**BIRKHOFF, HENDRICKS & CONWAY, L.L.P.**  
**CONSULTING ENGINEERS**

May 3, 2006

Re: Addison Town Center Replat

We have completed our second review of the replat for Lot 2, Block D of Addison Town Center. Our review is based on the Town of Addison's Code of Ordinances and Good Engineering and Survey Practice and does not relieve the registered surveyor of his responsibilities as the Surveyor of Record with the Texas Professional Land Surveying Practices Act. The following item is noted:

**REPLAT OF LOT 2, BLOCK D
ADDISON TOWN CENTER**

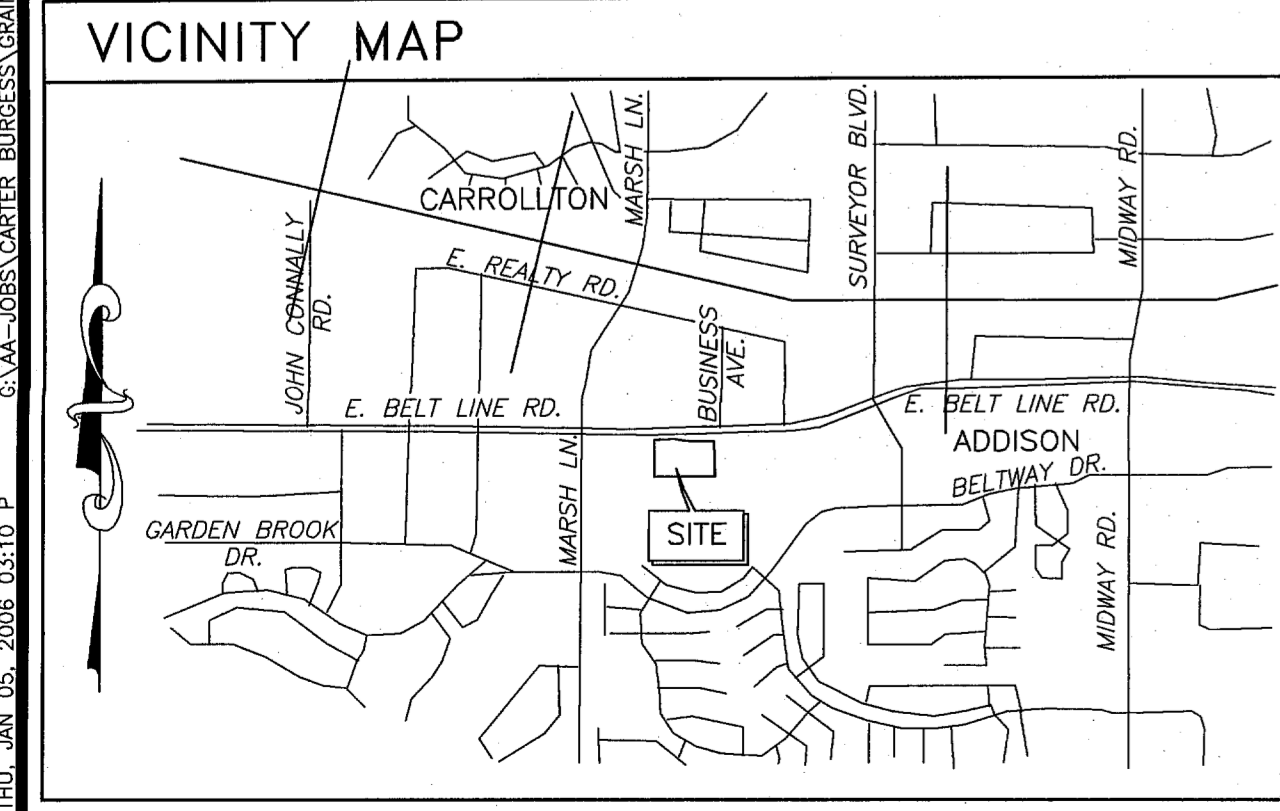
A statement must be made on the plat as to what was used for the horizontal control.

The first property line from the point of beginning has been labeled as a line of horizontal control. A reference bearing from the 'X' found east of the point of beginning should be provided on the plat.
